PROJECT NO. PR-2020-004820

# Memorandum

**Re:** Hotel Circle Ramada Apartment Conversion DRB Comment Responses (PR-2020-004820)

**AS103**

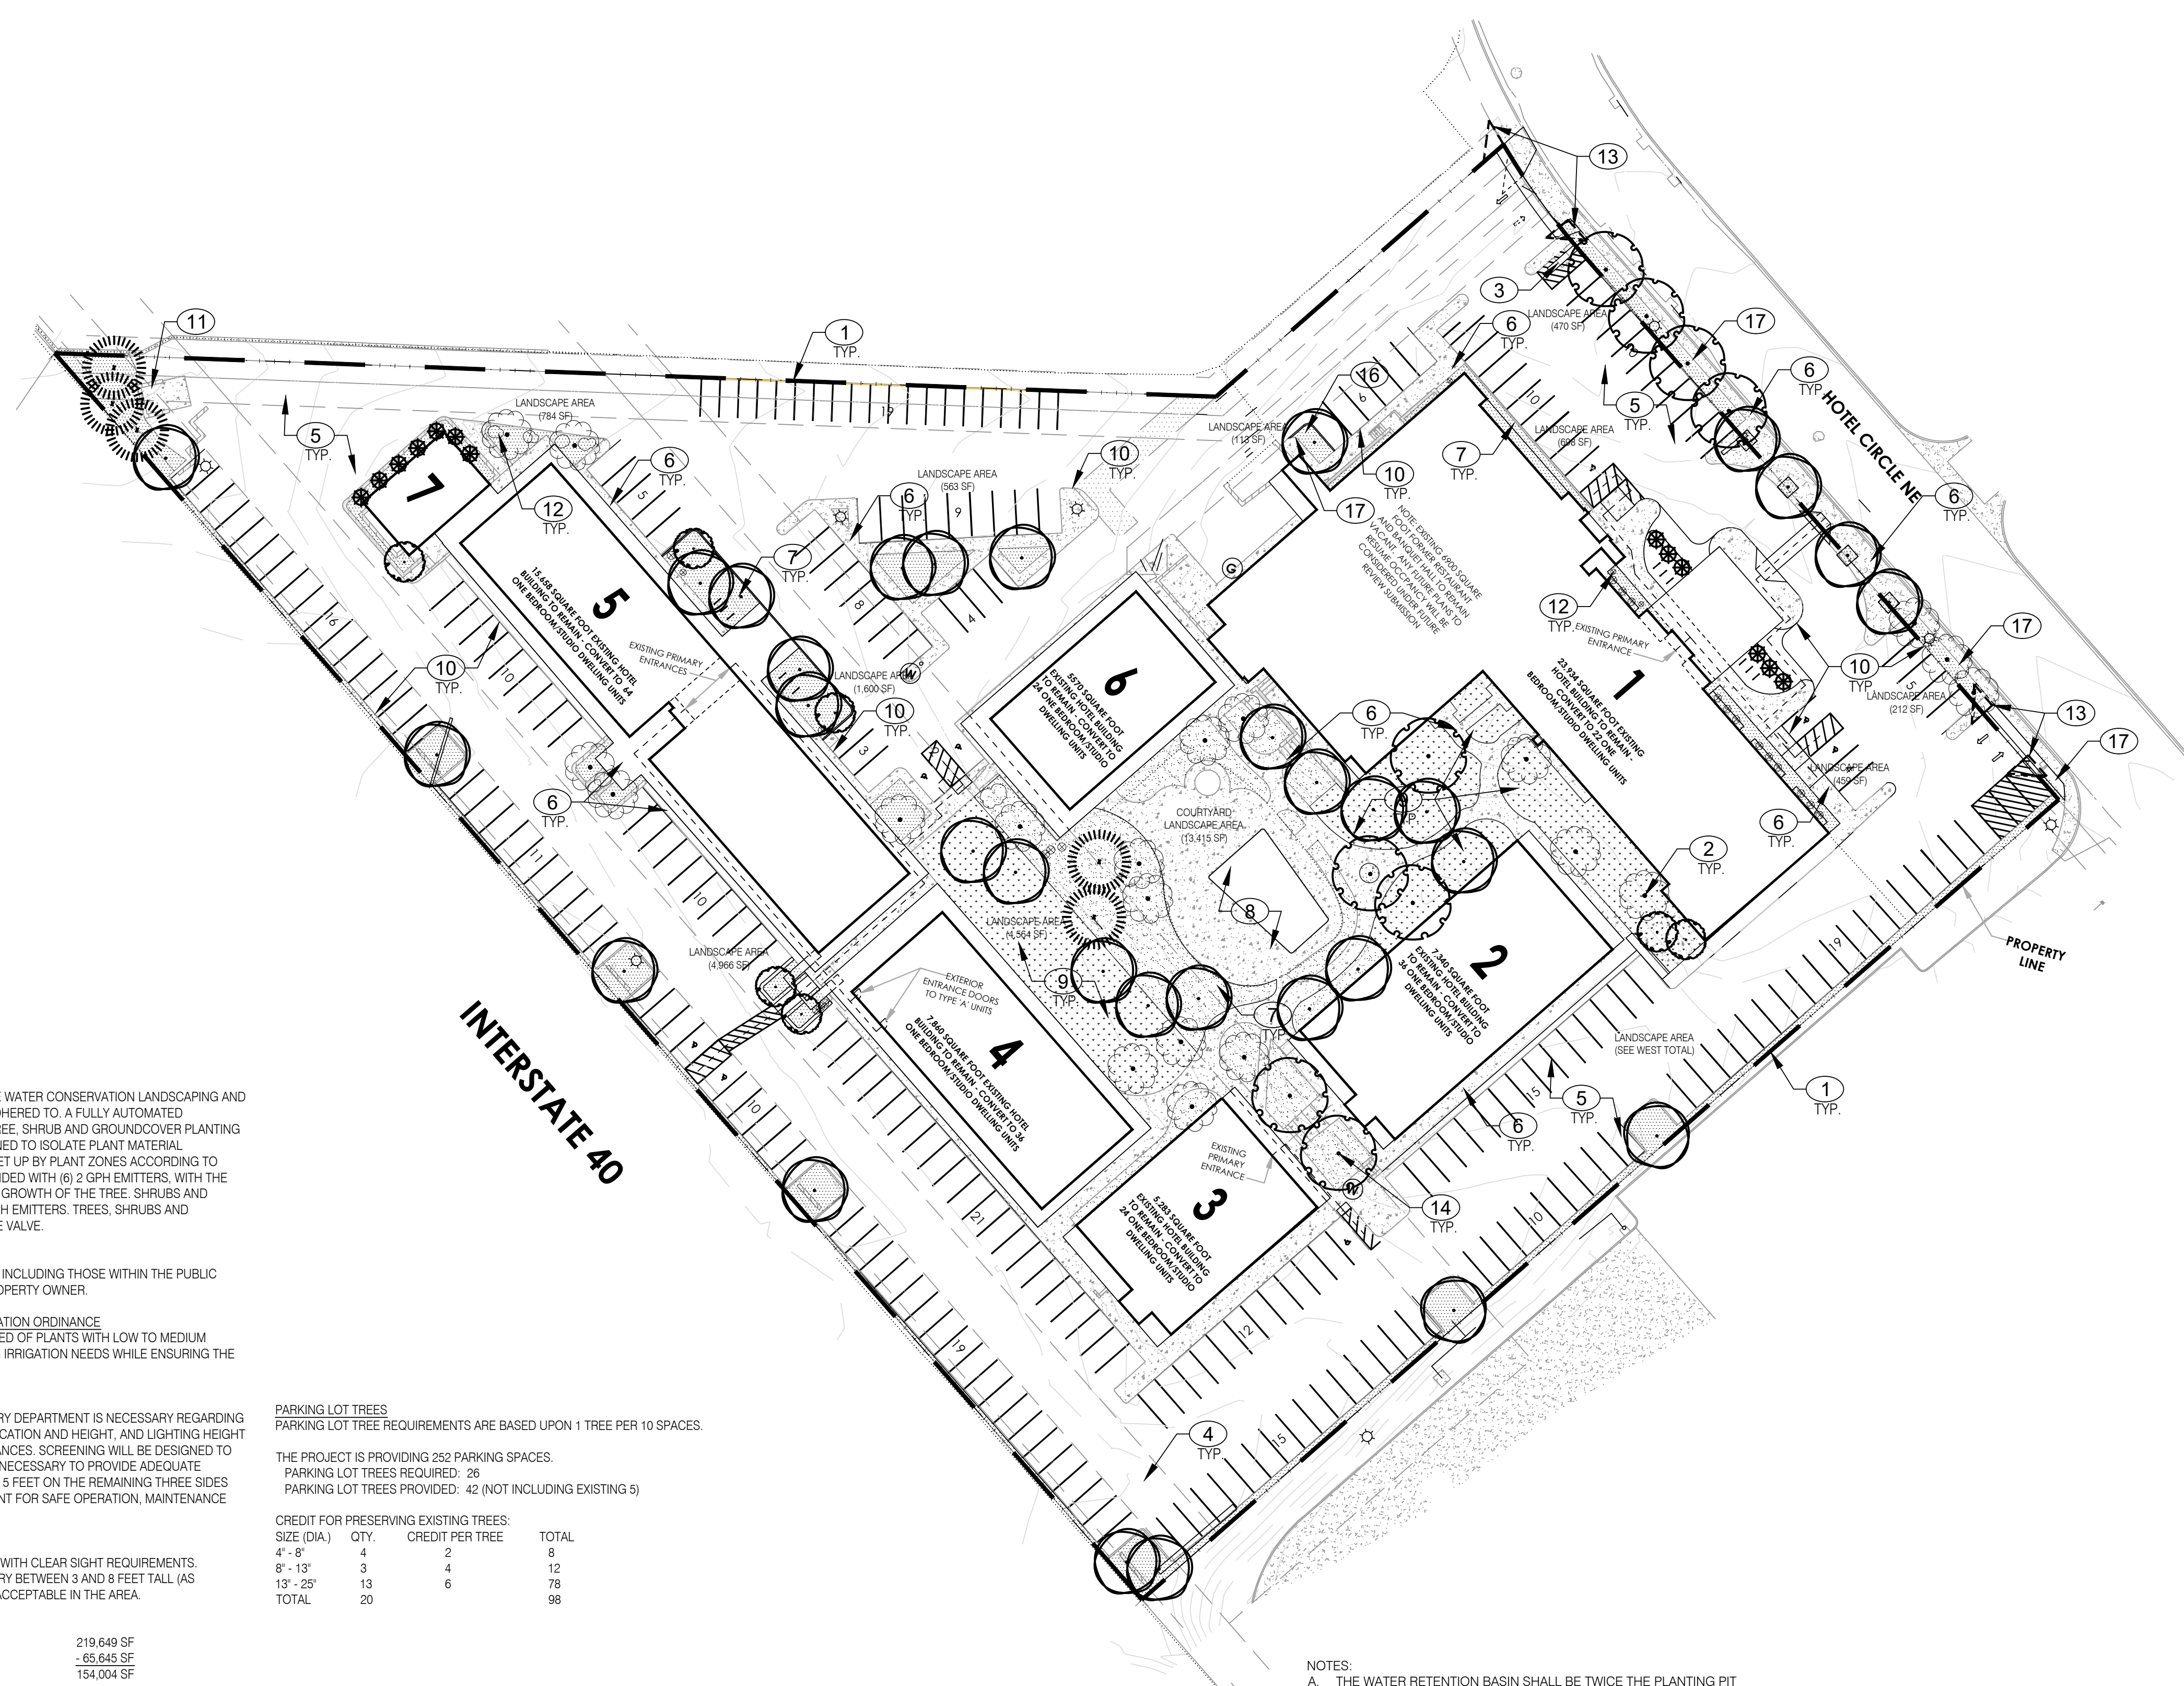
10. Provide details for the new curb, curb ramp, and sidewalk, and indicate a maximum 2% slope on the sidewalk. Curb should separate parking from sidewalks and landscape islands. Also show doorways to establish adequacy of pedestrian paths and ADA access. With notes, verify that any existing walkways establish a 6-foot ADA pathway to building and to right-of-way.

- a. ***See updated details on sheets AS102 and AS103, including sidewalk, curbs & gutter, and ramps. A 6-foot ADA pathway connecting the building to the public way is being created by this plan (see Keynote #30).***
